Case Officer: Rebekah Morgan

Recommendation: Approve

Proposal: Variation of condition 2 (plans) of 19/01740/HYBRID - reword condition to reflect the updated revisions to drawings as well as the inclusion of new ones

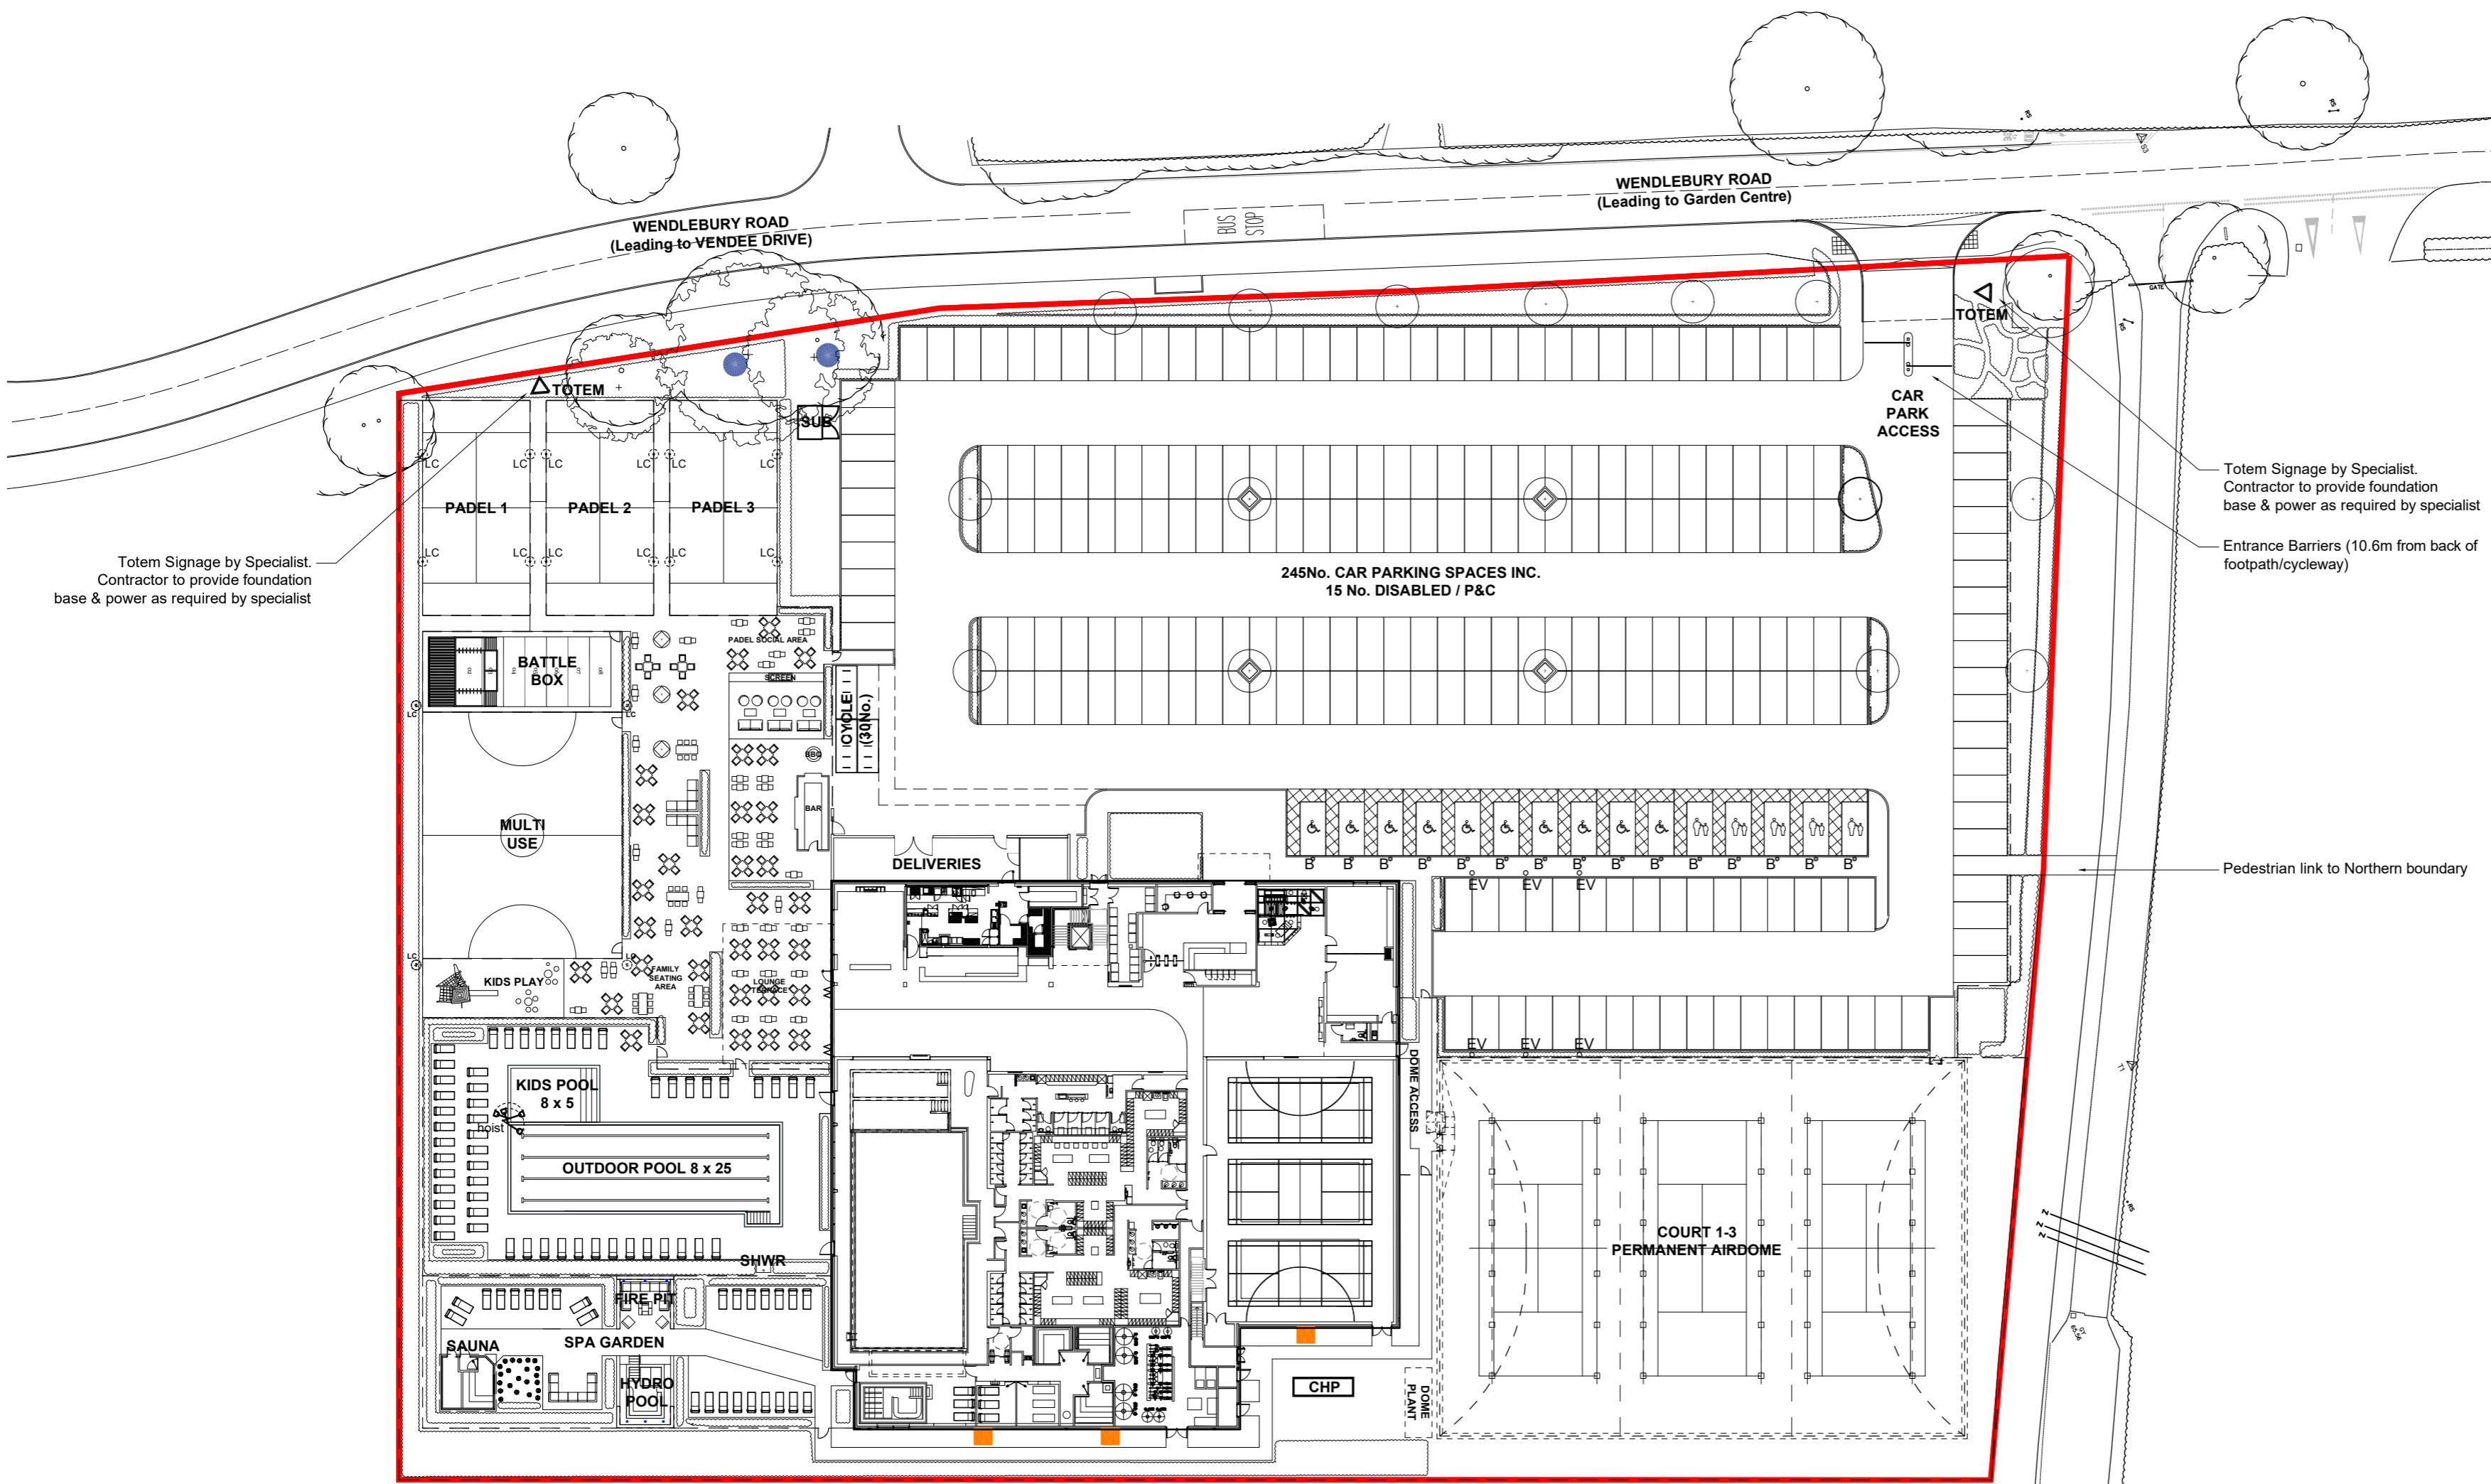
6.9. BICESTER BIKE USER'S GROUP: Our comments are related to the proposed cycle storage provision, which appears to consist of 30 covered 'Sheffield' stand type places.

The current guidance in Local Transport Note 1/20 recommends at Table 11-1 that leisure facilities provide:

- Short stay, obvious, easily accessed, and close to the destination of 1 place per 50m² capacity; and
- Long stay, secure and covered, of 1 per 5 employees.

In addition, the provision should consist of at least 5% of the places for non-standard and adapted bicycles for the disabled.

As a result, the current proposed provision does not appear to meet with the guidance. We therefore would object to the application unless it were to be revised to include:

- Sufficient short stay provision;
- Sufficient long stay provision with adequate security; and
- For both, minimum of 5% provision for non-standard and adapted bicycles.

- 8.4. The comments of Bicester Bike User's Group in relation to cycle parking provision have been noted, however, the application does not propose any change to the level of cycle parking provision previously agreed under application 19/01740/HYBRID. The permission is still extant and was implemented to develop the scheme to date. There has been no material change of circumstances that could justify requesting additional cycle parking provision at this stage.

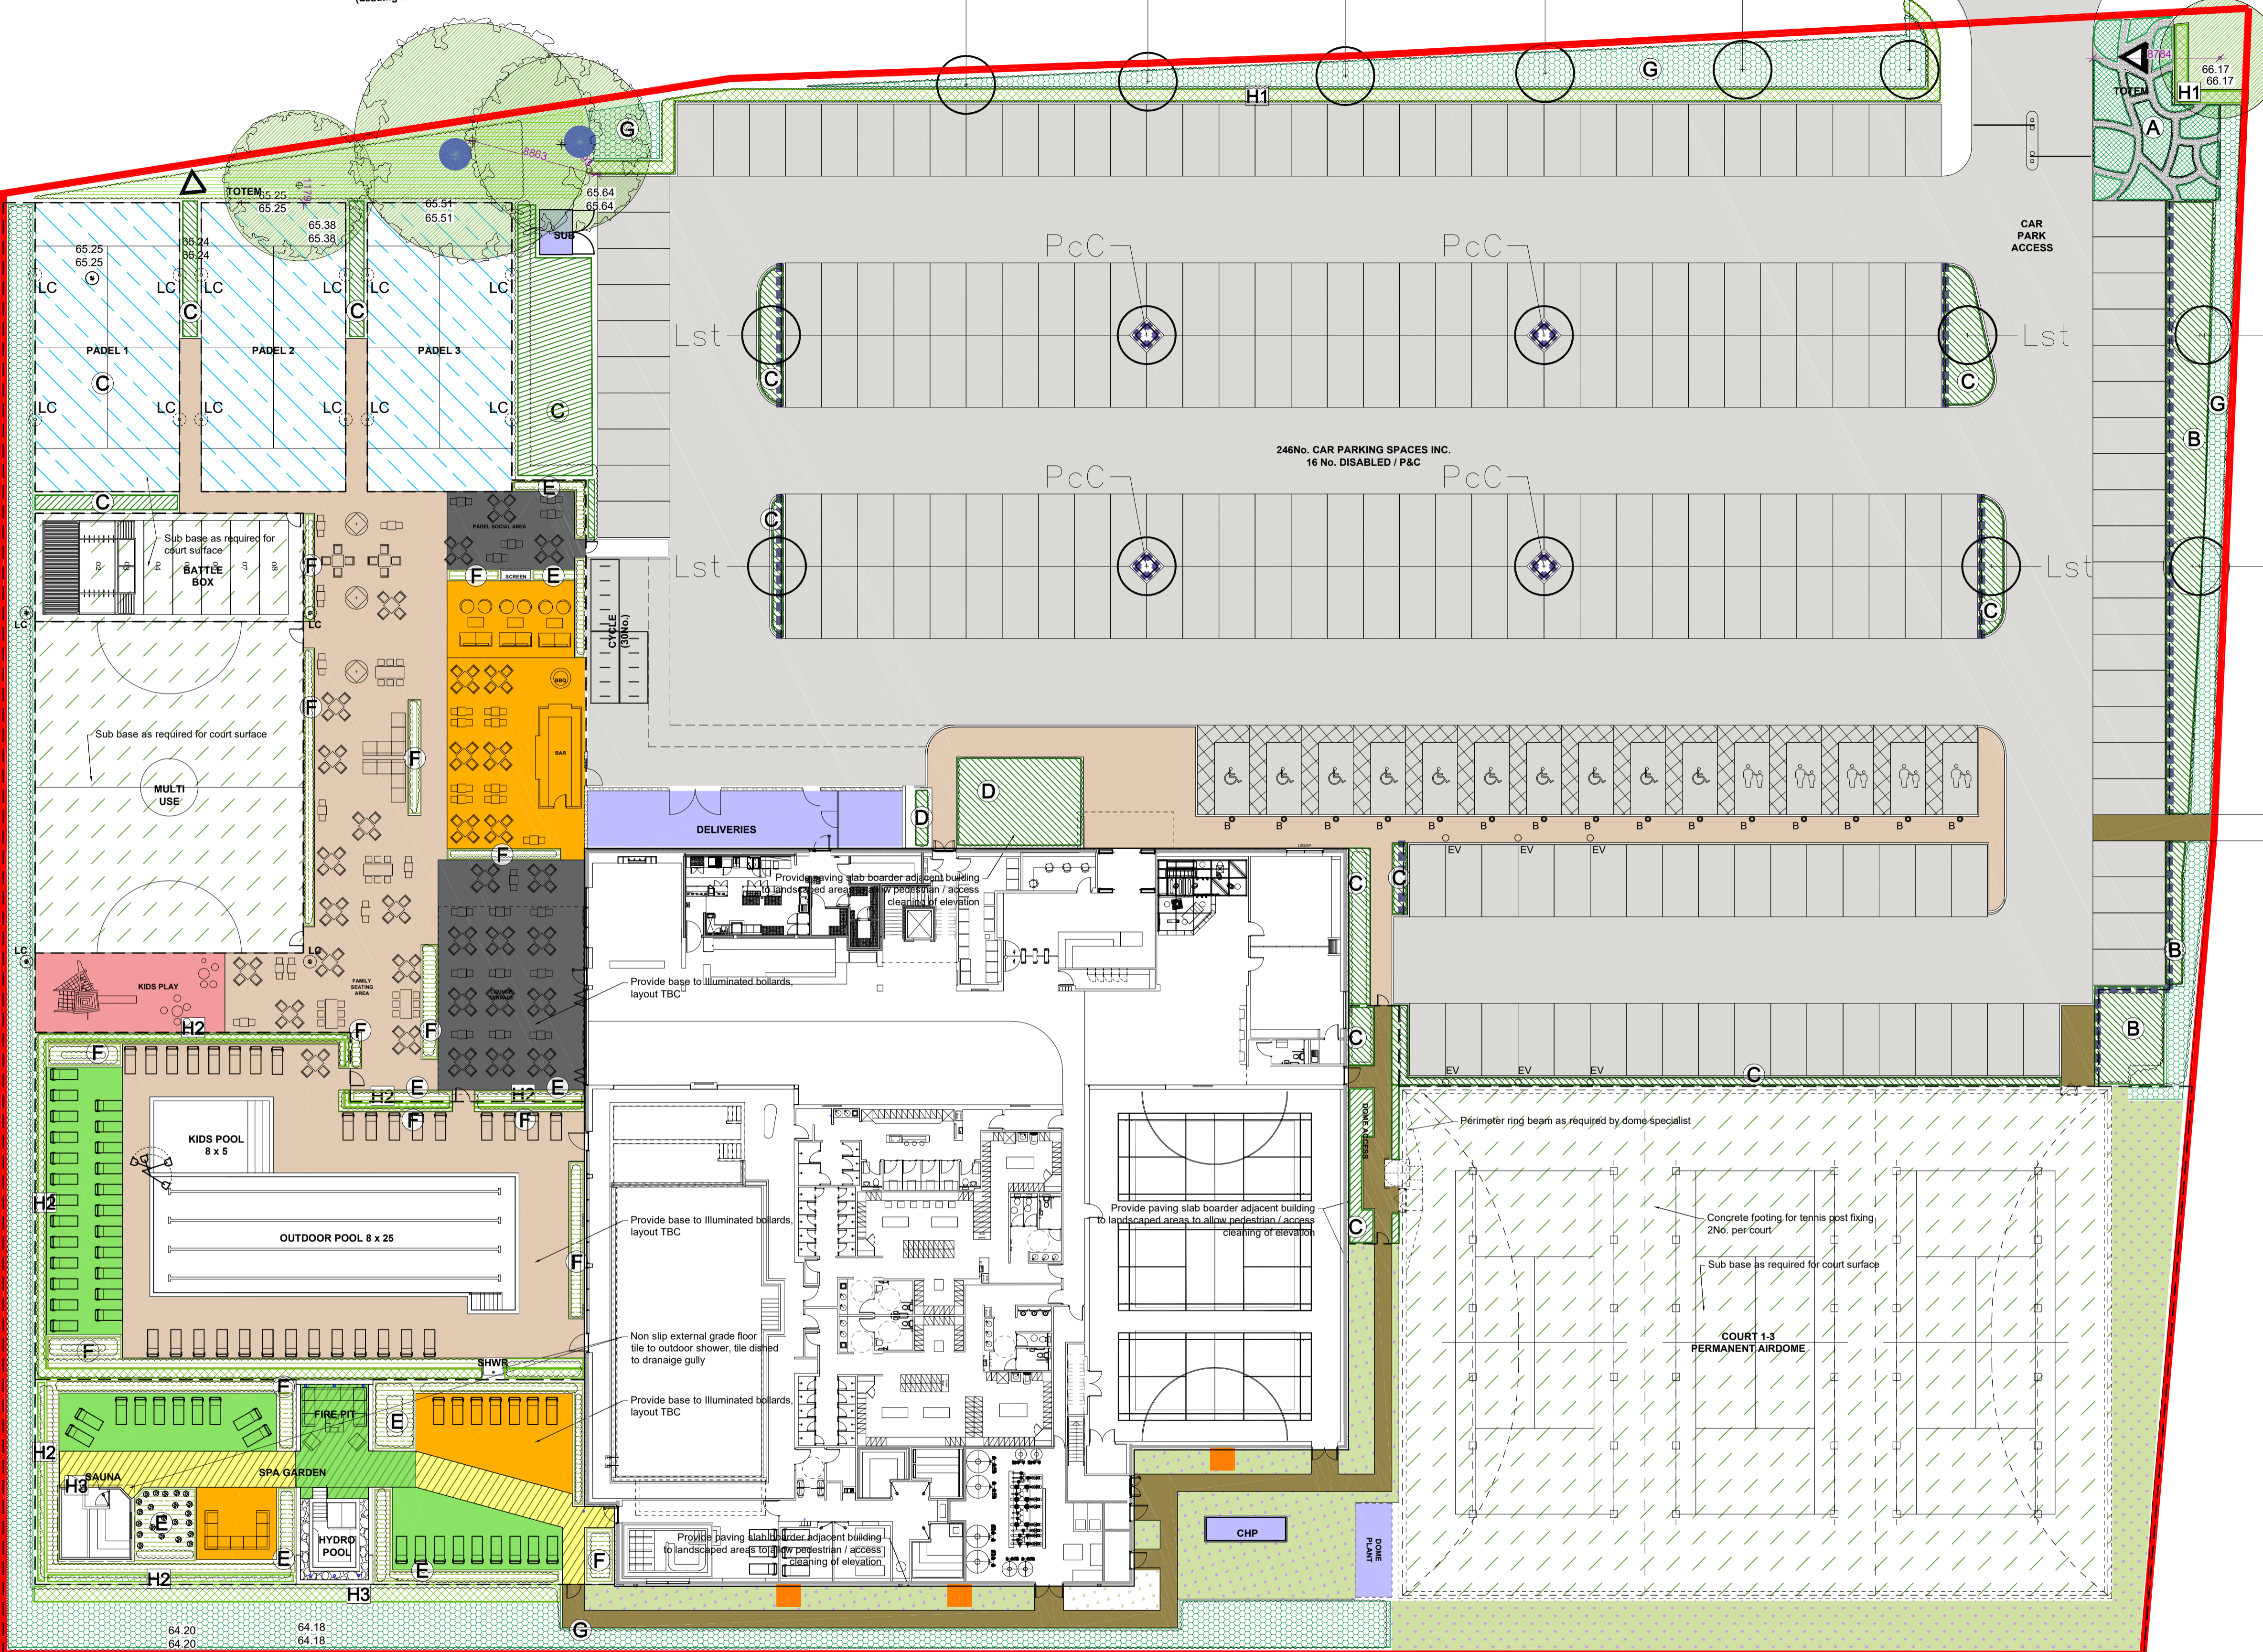
Proposed Surfacing and Landscape Plan: A substantial amount of native structural vegetation has been removed from the frontage of Wendlebury Road for the benefit of highway vis play, roundabout and road realignment and widening. This has

exposed the site where visual receptors experience harmful construction impacts, operational and physical impacts of large car park and buildings where once there was an attractive country lane. The proposed *Fagus sylvatica* hedge is too formal and does not have the species (flora and fauna) diversity and visual richness of a native mixed hedgerow, which is required here - not forgetting an improved BREEAM score for the overall development. The mixed native hedgerow will require a 1 m wide wildflower verges on both north and south sides; against the pedestrian route and the car park to allow for the growth of the hedgerow. The regimented row of trees is too formal and irregular spaced native trees in groups are required. The hedgerow should be implemented at the earliest opportunity during the current planting season with appropriate landscape maintenance to aid its establishment and facilitate growth, whilst site clearance and construction proceeds. This will provide some visual benefit, but also reassurances that the construction/operational and visual impacts are being addressed at the earliest opportunity.

The potential 'heat island' effect and the harmful visual impact of such a large car park must be addressed for the benefit of onsite users. Additional, climate enhancing, trees should be planted in the car park where space, services and parking bay numbers allow. It has been established that groups of trees sharing the same larger volume tree pit establish and perform better than single trees in isolated tree pits. I would prefer to see larger treed areas protected by knee rail and understory planting. All trees are to be supplied, handling, planted and established in accordance with the current British Standard BS 8545: 2014 The *Pyrus calleryana* 'Chanticleer' are generally ubiquitous; they are prone to ugly, wound healing deformations to the main stem. Therefore, replace this cultivar with *Ginkgo biloba* trees with the more attractive bark. Tree pit details are going to be necessary. Root barriers should be considered, and their positions indicated on the landscape proposals.

Proposed Tree Strategy: The proposed trees for open space and street should be appropriate in terms of 'Right Tree Right Place' and I therefore recommend that the landscape consultant to consider TDAG's tree species selection for green infrastructure at the earliest opportunity. The revised layout should accommodate more street trees to be adopted and maintained by OCC.

Planting – general: The planting distances are incorrect and planting density should be increased for most species. Good ground coverage is required after 2-3 growing seasons. For example, the *Potentilla fruticosa* 'Abbotswood' is proposed to be planted at 0.71 m apart which is far too open. I recommend 3 P.f 'Abottswood' plants per sq. m to achieve the desired effect. All plant densities should be looked at again and the nos./sqm rule imposed.

There is no instruction to plant in species groups or drifts of 3, 5 or 7. This appears to be left to the landscape contractor during site operations. There is even no instruction to ensure the species are not planted too close to the edge of borders. This may happen, whereas species grow over the path they will be unsympathetically pruned.

Plant bed C border between the car park the dome is too narrow for effective establishment of plant species and will be overshadowed by the dome. There will be insufficient topsoil and drainage because the concrete haunching to retain the edge of the paving and playing surface will be very substantial. Delete this border and replace with free-draining gravel surface. The dome and the adjoining car park are visually onerous and tree planting in the car parking is appropriate to visually mitigate these elements.

The maintenance proposals should be clarified with current British Standards – refer enclosed crib sheet.

Landscape Management: The Landscape Management notes on the drawing are limited in their explanations and are confused with the more detailed LEMP. These notes should therefore be deleted off the drawing. Shrubs should be pruned at the correct times to enhance flowering and the production of fruits for visual appeal and food source for birds. For the proposed trees there should be inspections, hand weeding, mulching, stake and tie adjustment, formative pruning and ground moisture monitoring and watering at appropriate times, all in accordance with BS 8545. It should also mention that dead, dying and diseased trees are to be replaced.
